From: Amanda Scholes on behalf of Planning.Responses
Sent: 09 November 2020 08:44
To: Planning Scanning
Subject: FW: 3421 - 55-57 River Road - EA FRA response Ref HA/2020/122604/01-L01

Please treat the document as a substitute FRA. The updated flood data requires the finished floor levels (FFL) of the wing adjacent to 47 River Road to be raised by 4cm. I can amend the plans and elevations to

To highlight, the product 4 confirms the flood levels would reach up to 4.87m AOD for a 1:200 yr AEP event in 2115. Allowing a 300mm freeboard, the habitable place would be protected to the required level of 5.17m AOD. JPA will update the levels to suit.

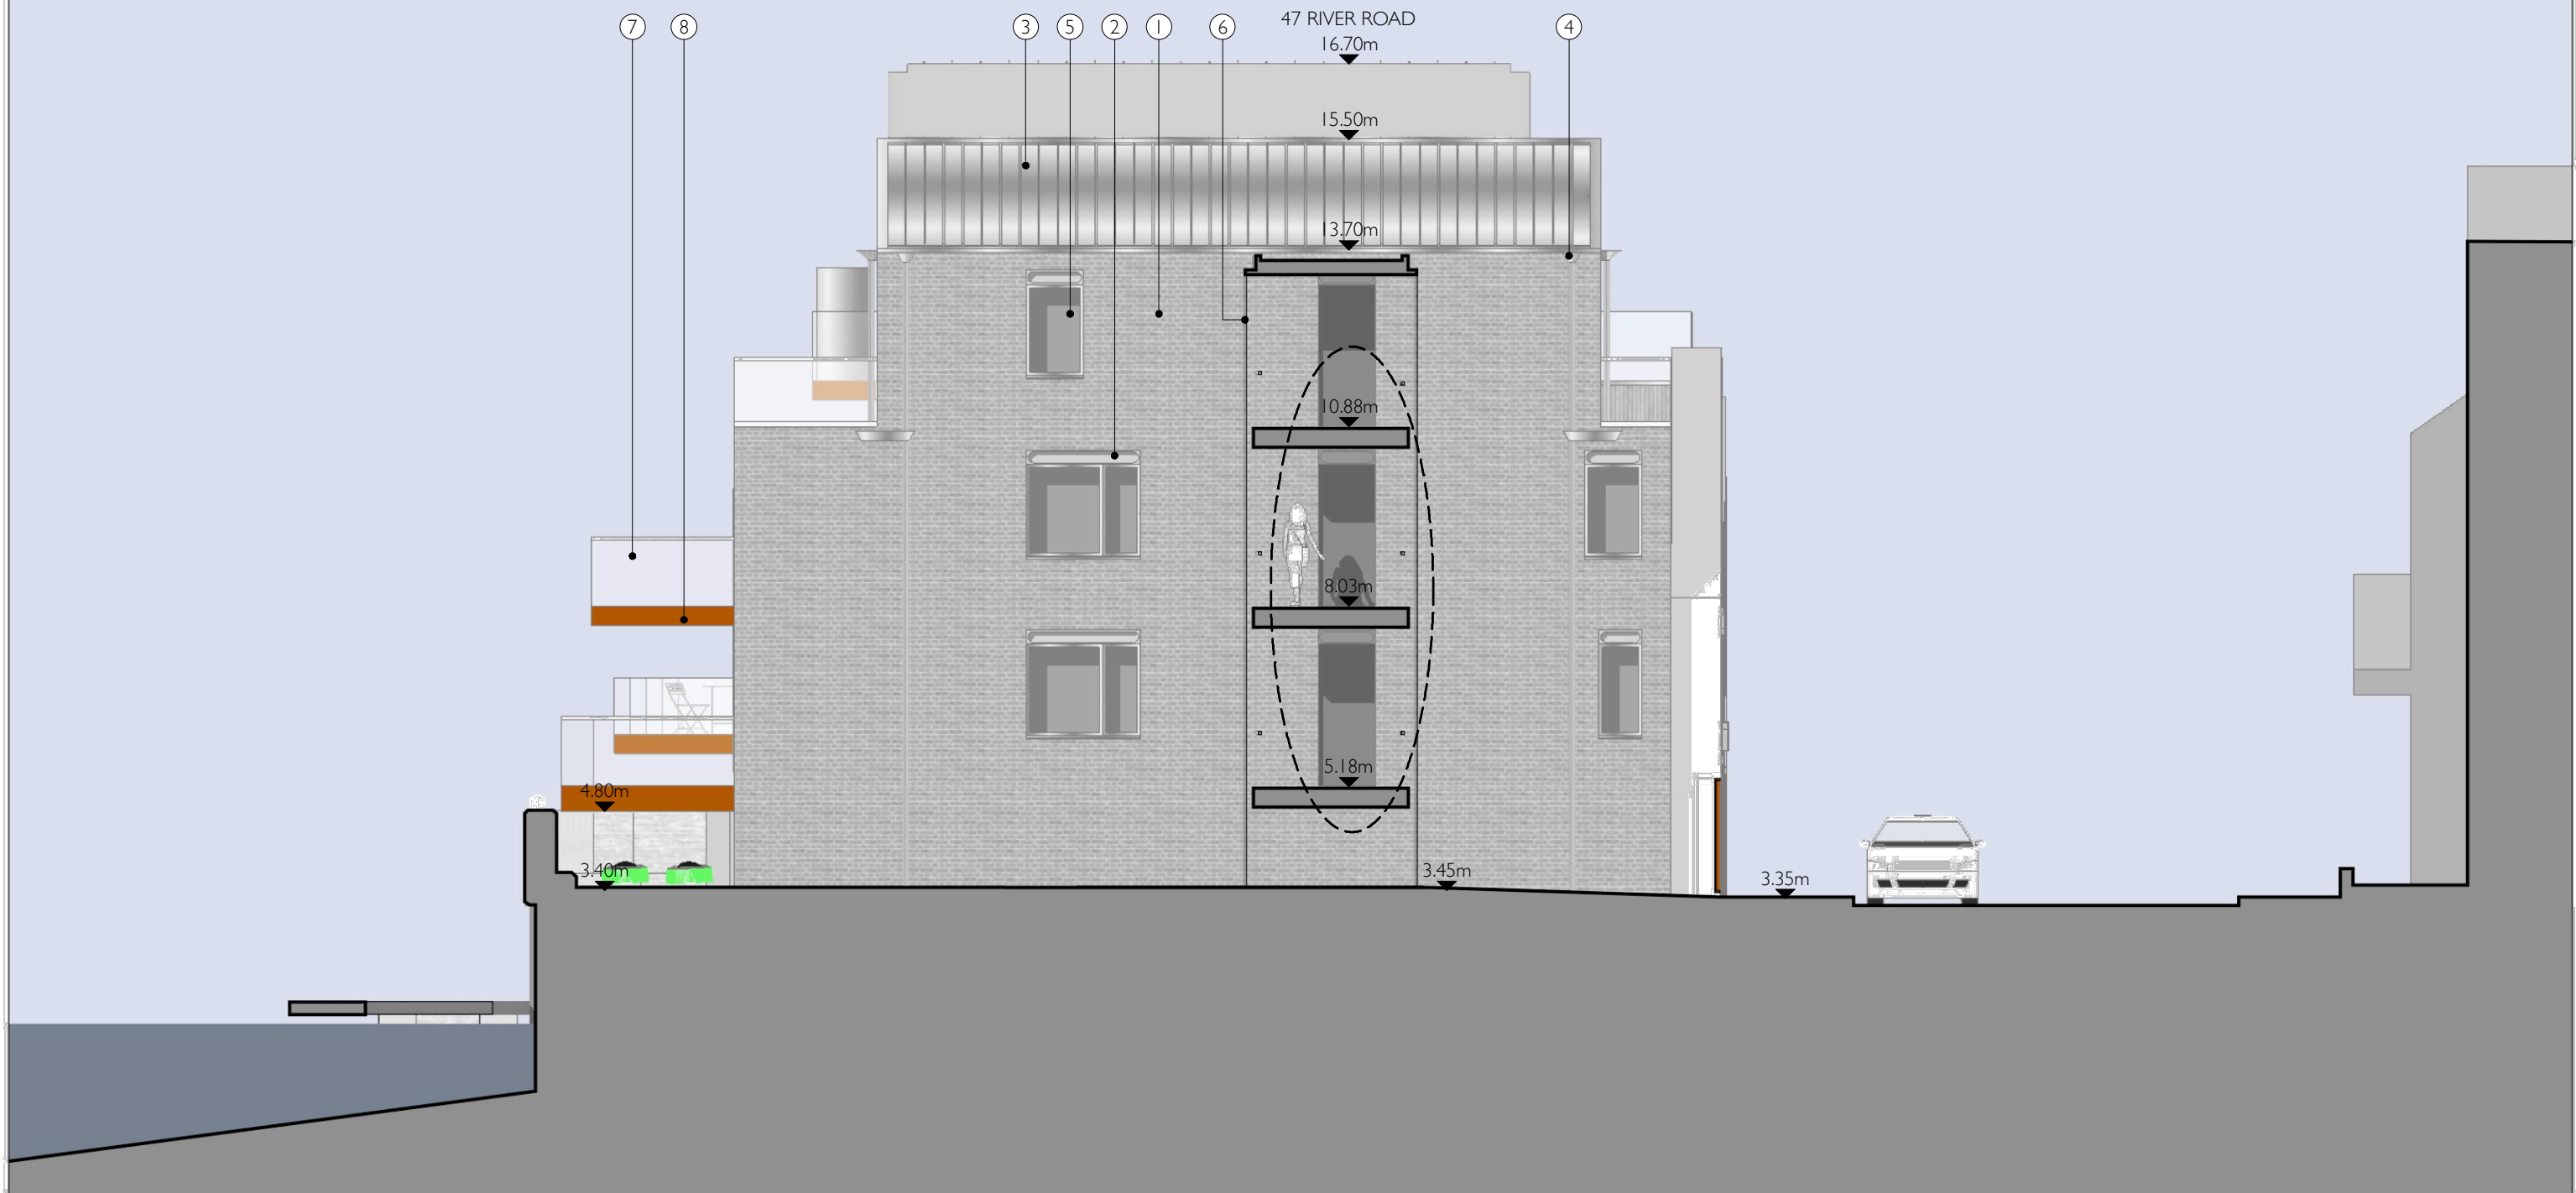
reflect this with a note confirming what will be a fairly indiscernible change? The overall height of the wing won't change as the roof pitch can be fractionally reduced. Alternatively I wondered if a condition noting that the FFLs must be no lower than 5.17m AOD would be an acceptable way of dealing with the issue?

Just to clarify we agree with the methodology of your FRA, however the data from the EA which you included in your FRA appendix, for which you base the levels on, is from 2013 which is somewhat out of date. As per my response (Advice to Local Planning Authority/Applicant – Flood Data) you will need to provide an FRA with the most up-to-date data available.
